DEVELOPMENT REVIEW COORDINATOR  
POST APPROVAL PROJECT CHECKLIST

Project Name: Luminato

Project Address: 167-169 Newbury Str.

Site Plan ID Number: 2016-021

1st FLOOR PARKING—FEDERAL STREET ENTRANCE

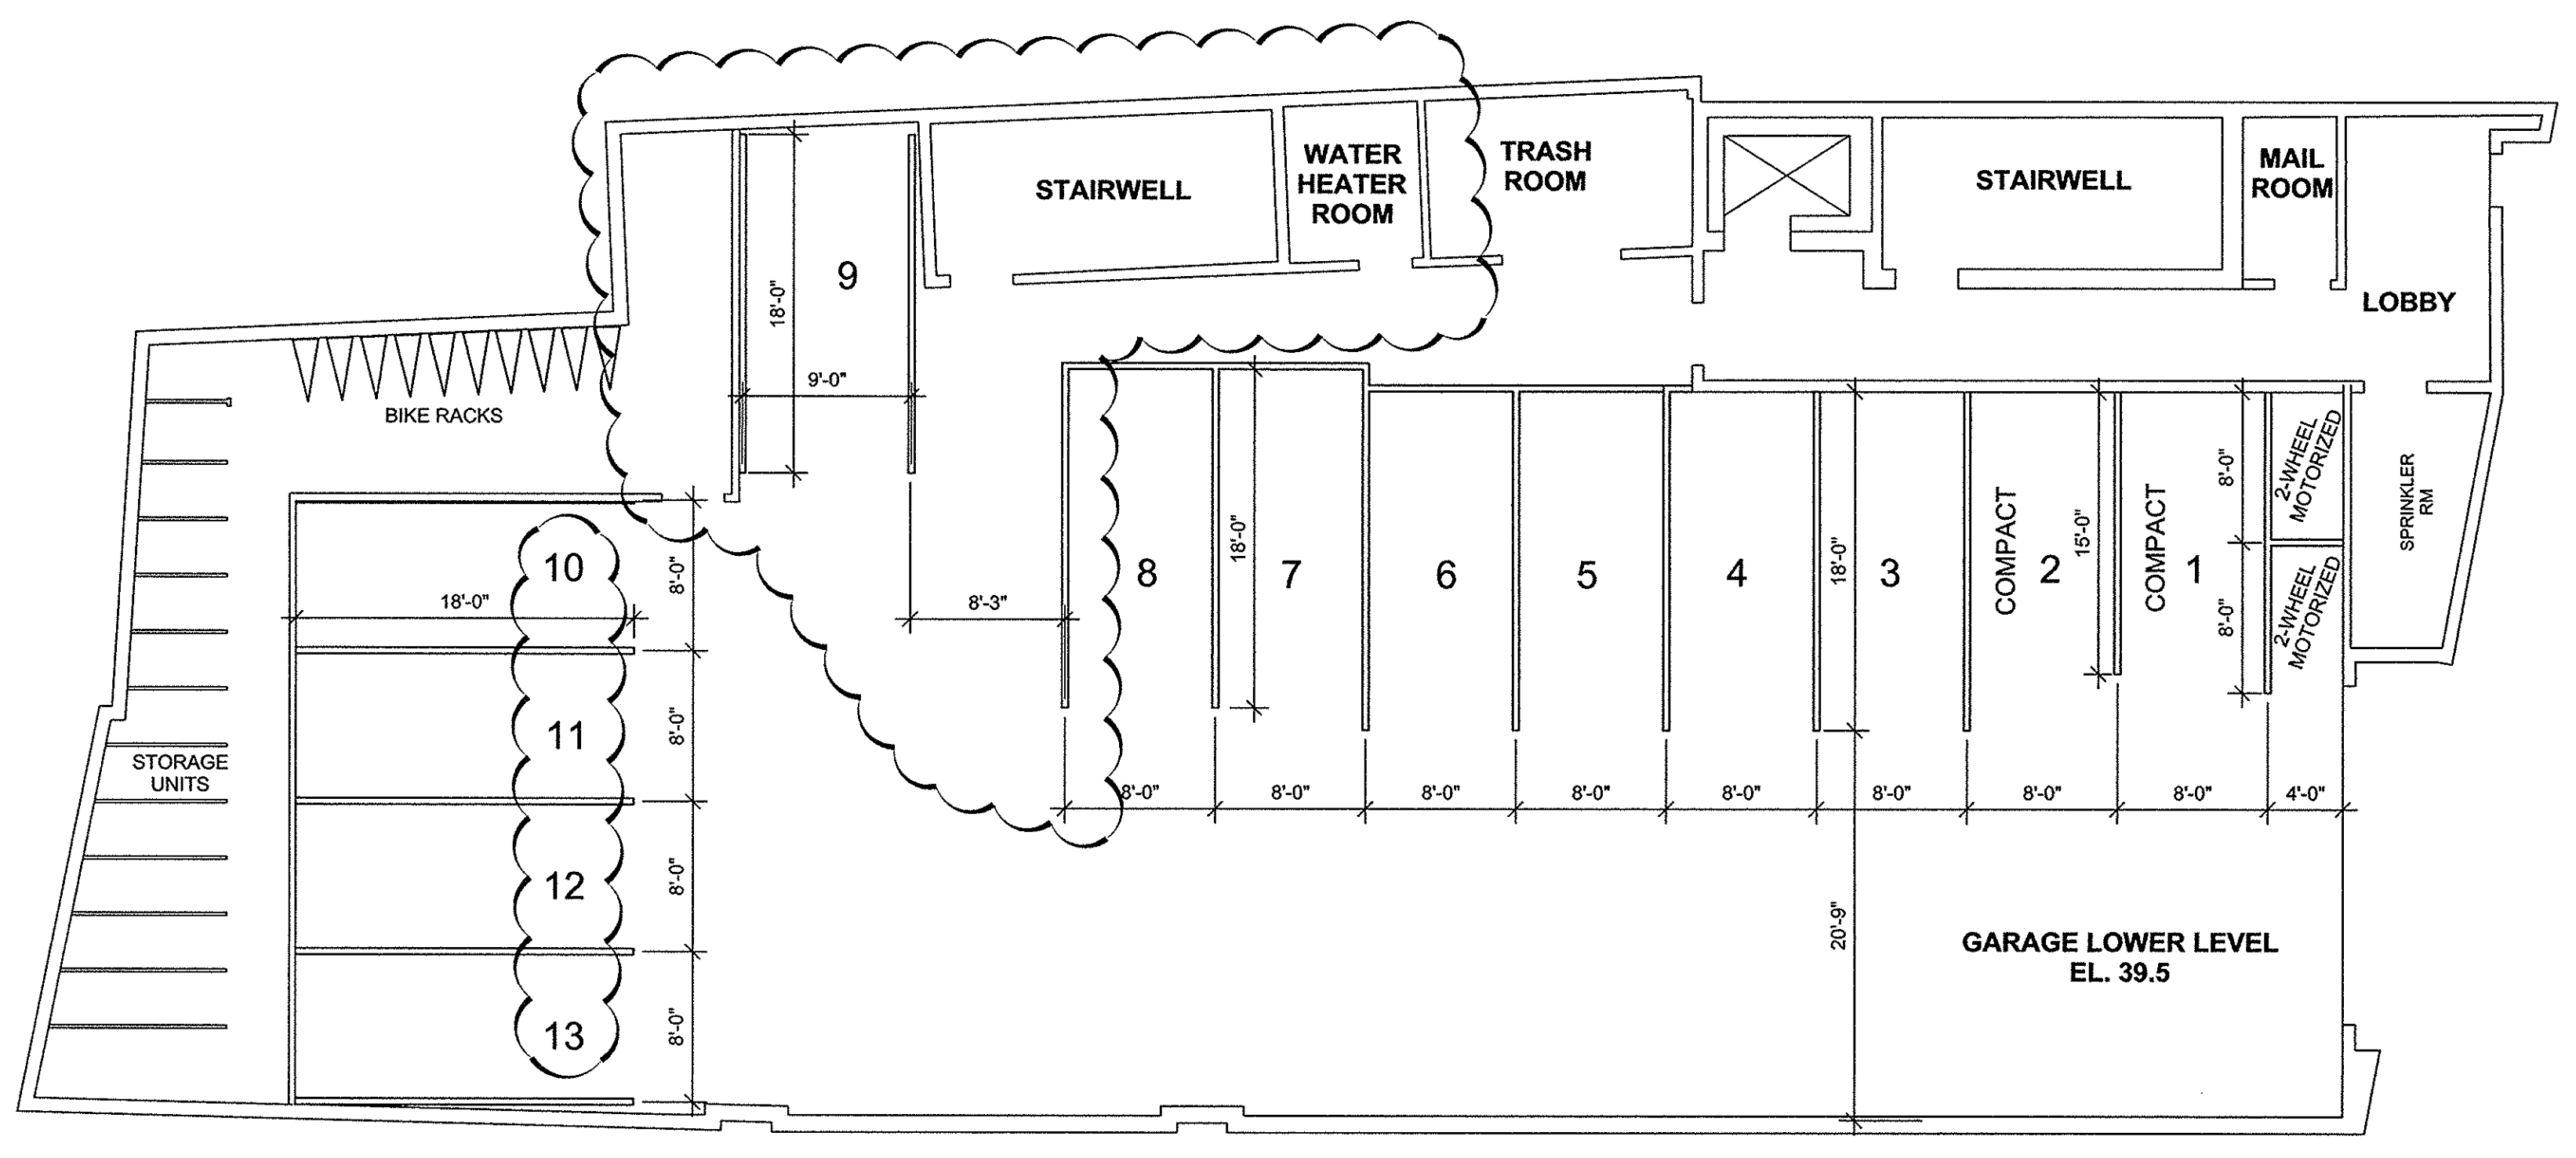
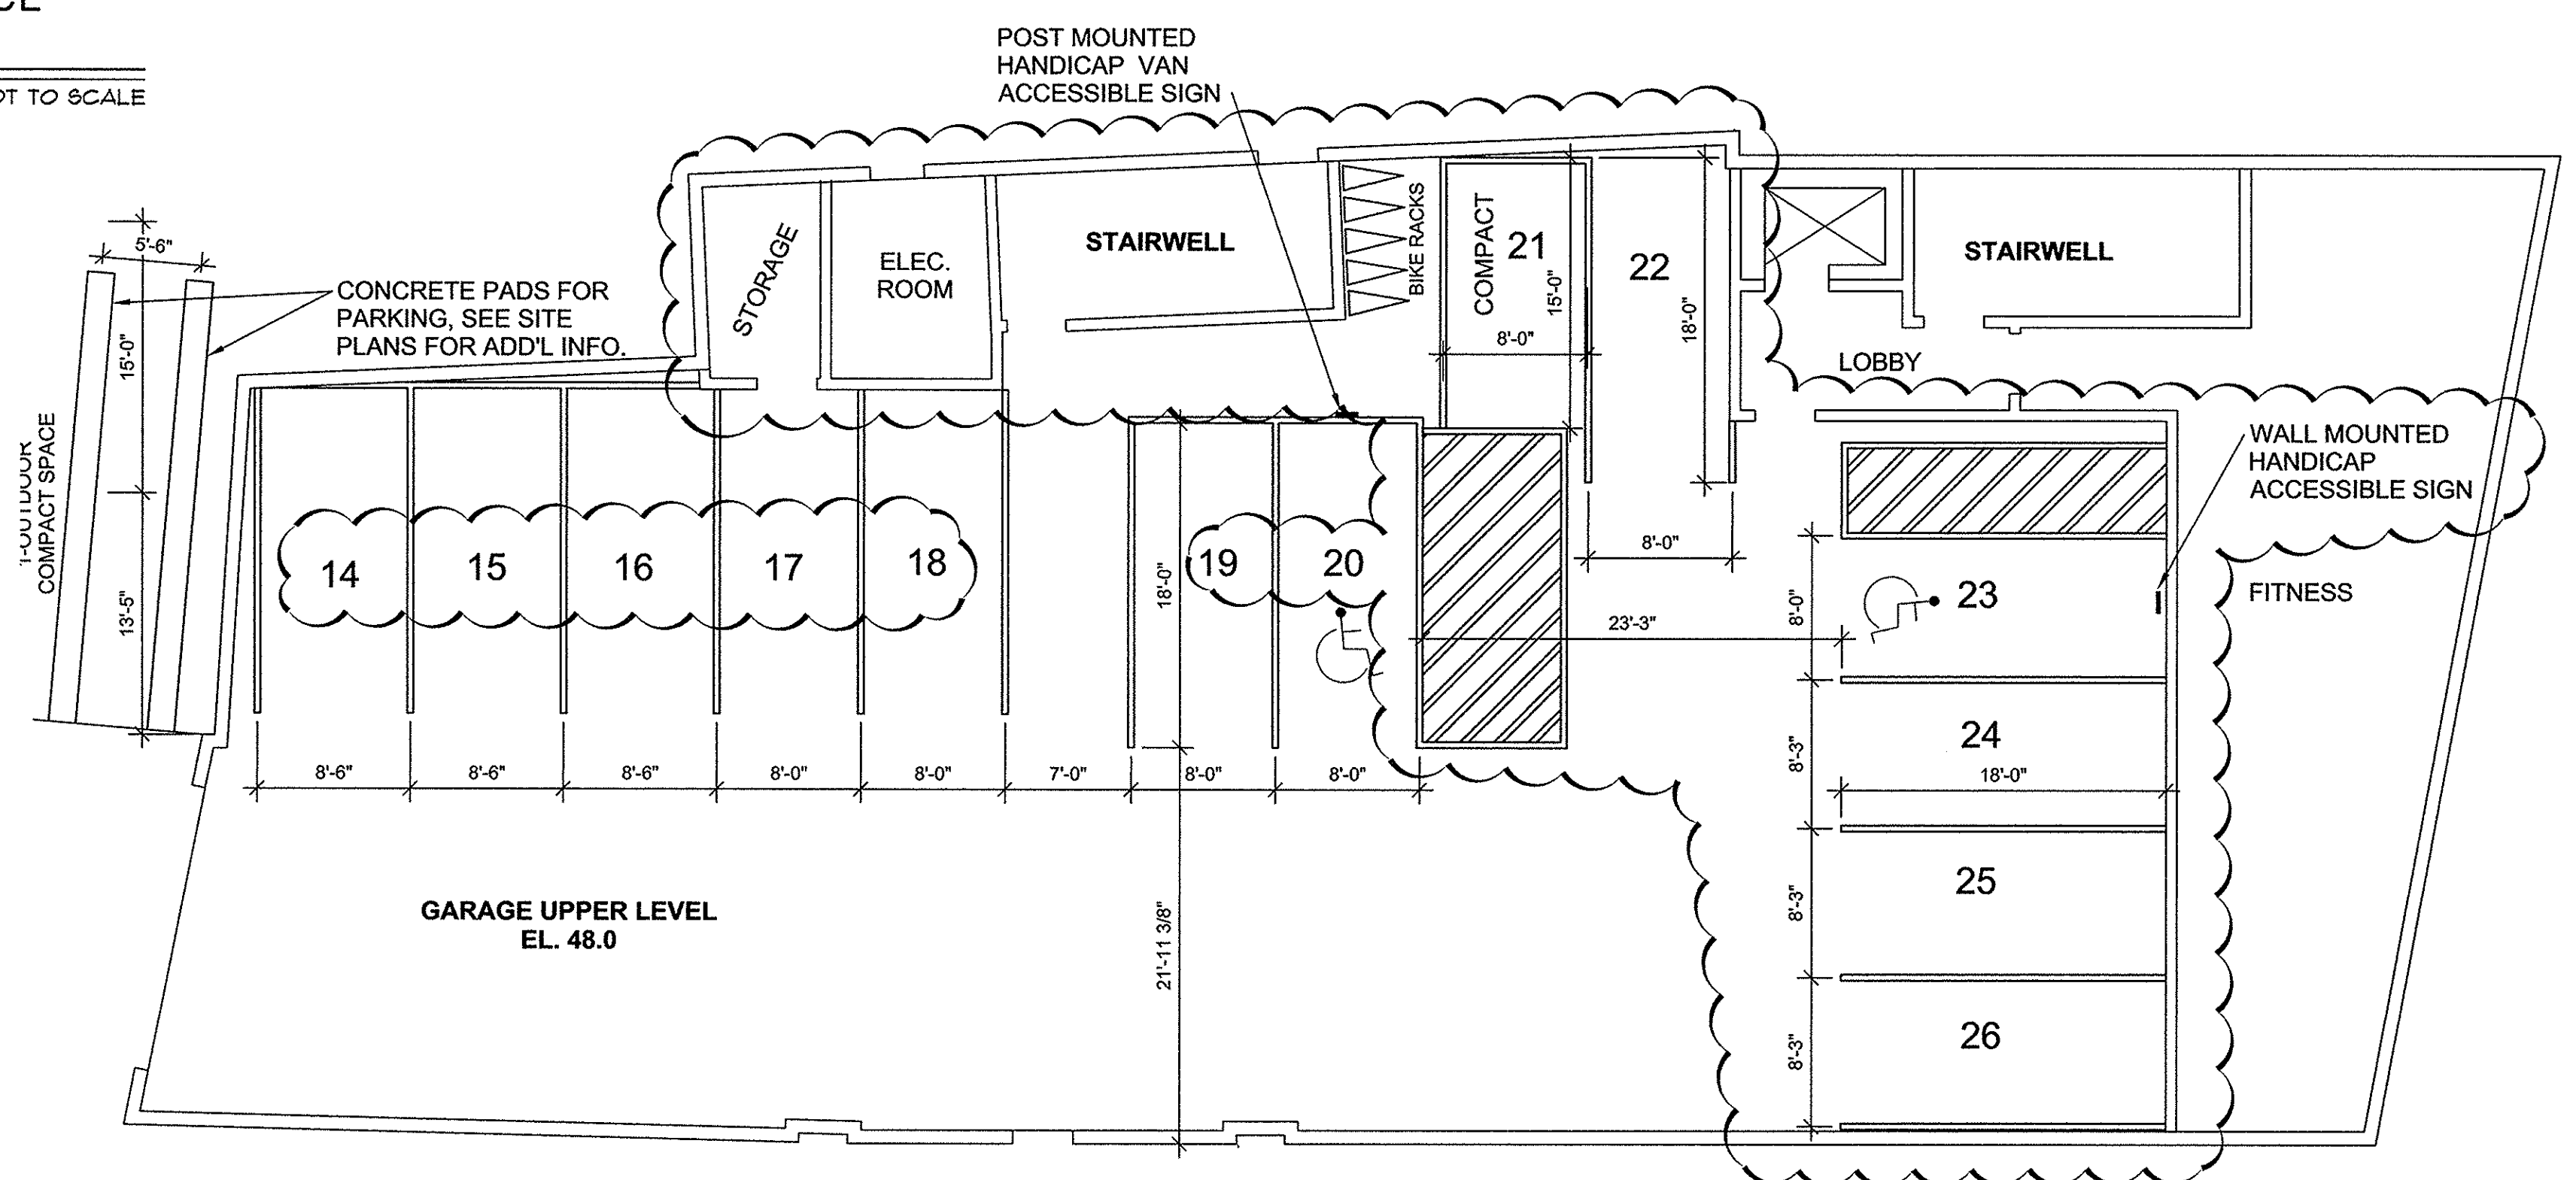
- The applicant should provide vehicle turning templates for parking spaces to document accessibility.

- The parking area layout requires several waivers including aisle width, parking space dimensions, and the number of compact parking spaces. The applicant should provide detailed documentation on justification for waiving City standards. All parking spaces and aisle widths should be dimensioned.

**Status: The applicant has provided turning templates for the parking spaces and the information notes that parking maneuvers can occur within the site. I have no further comment, but my assumption for approval is that backing maneuvers are not required onto Newbury Street and Federal Street.**

**Status: Supporting documentation on waivers from the City's Technical standards have not been provided.**
